Our Ref: EG/69/14/HH

Erect a car port – Cedar End, Eastergate (our ref: EG/69/14/HH)

Client	Mr E Yule
Project	Cedar End Eastergate Lane Westergate West Sussex PO20 3SJ
Drawing Title	Oak Framed Cart Lodge Plan Section & Elevations

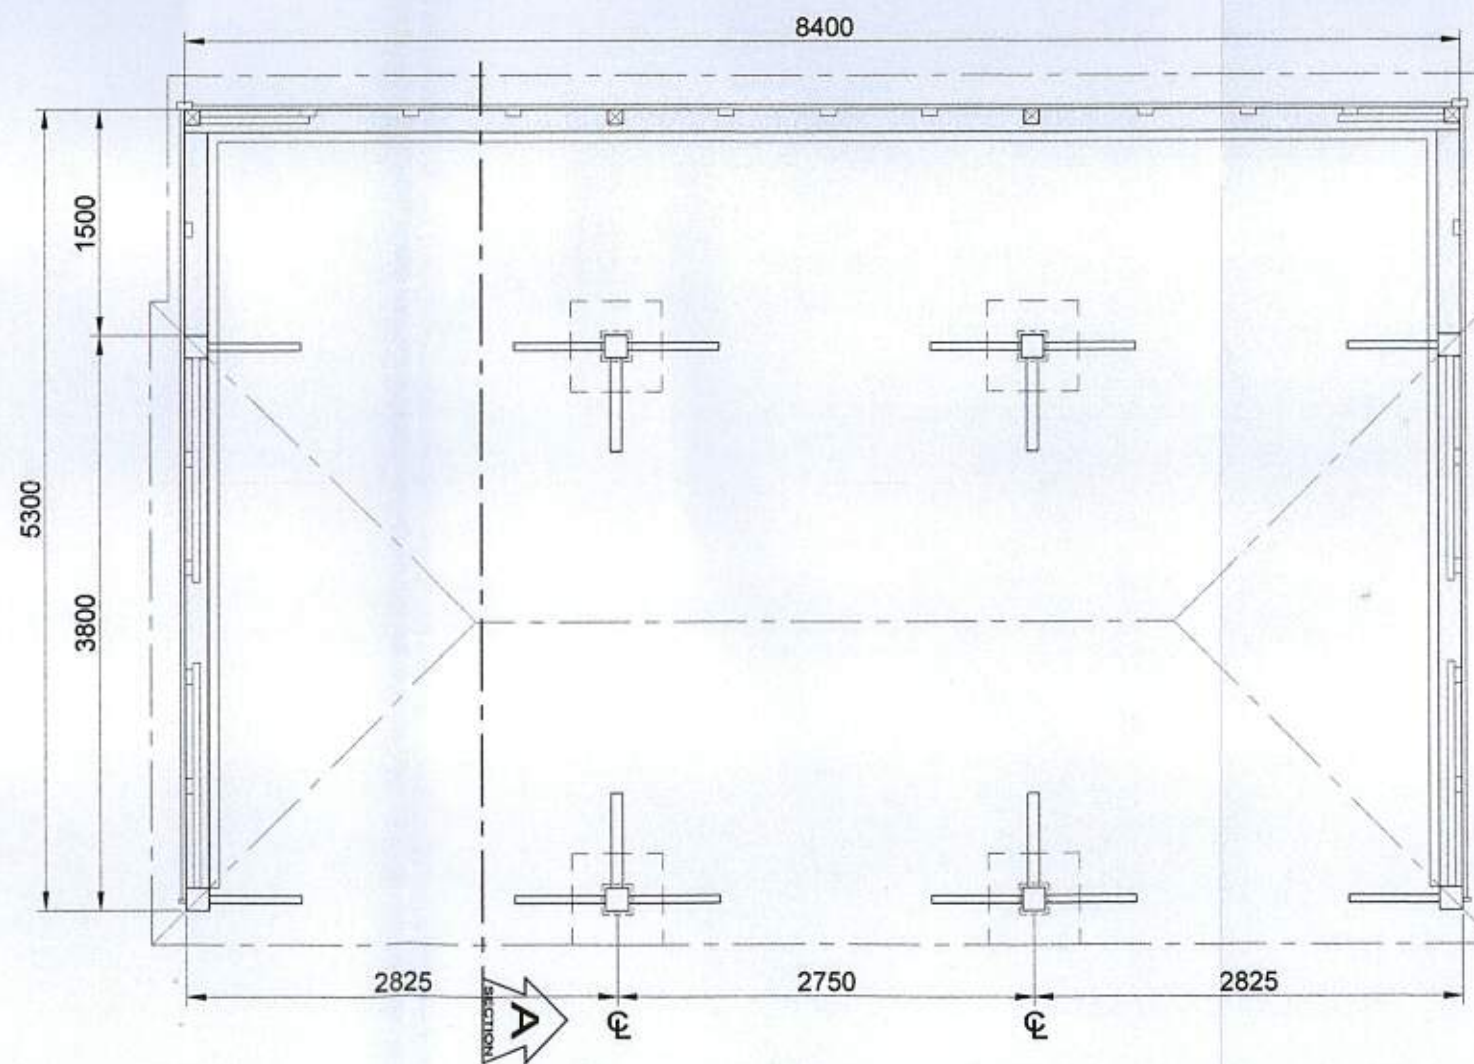
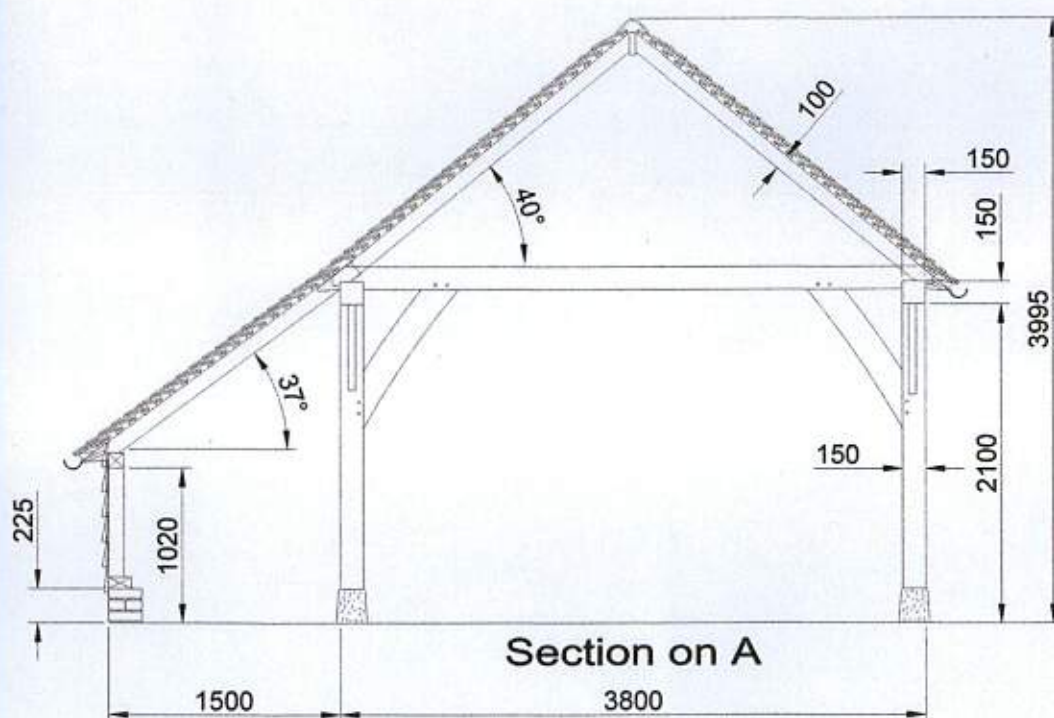
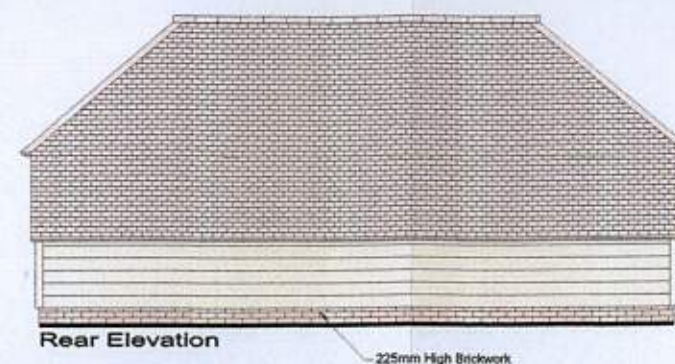
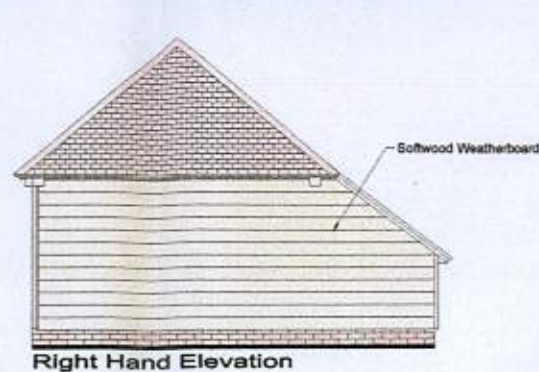
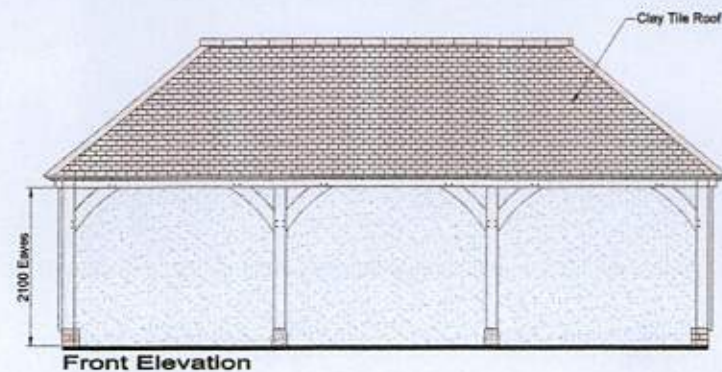
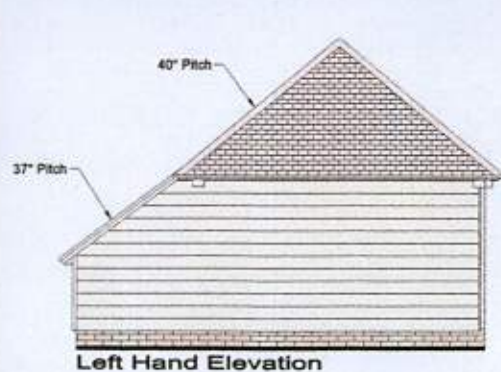
I am currently reviewing the plans you have submitted to us in relation to your application to erect a car port on your property. I have noticed a discrepancy within these plans. The building shown on the 1:500 Site Plan includes stairs to a games room. The floor plan and elevation drawings make no reference to any stairs or to the use of the roof space as a games room.

Could you please confirm to me whether the proposed building is intended to be used to house a games room? If this is the case then the current floor plan and elevation drawing will need to be amended to show the stairs to the games room and details of any windows or openings within the roof. If this is not the case, the reference to stairs shown on the 1:500 Site Plan will need to be removed.

Based on the elevations provided it does not appear feasible to create a games room in the roof.
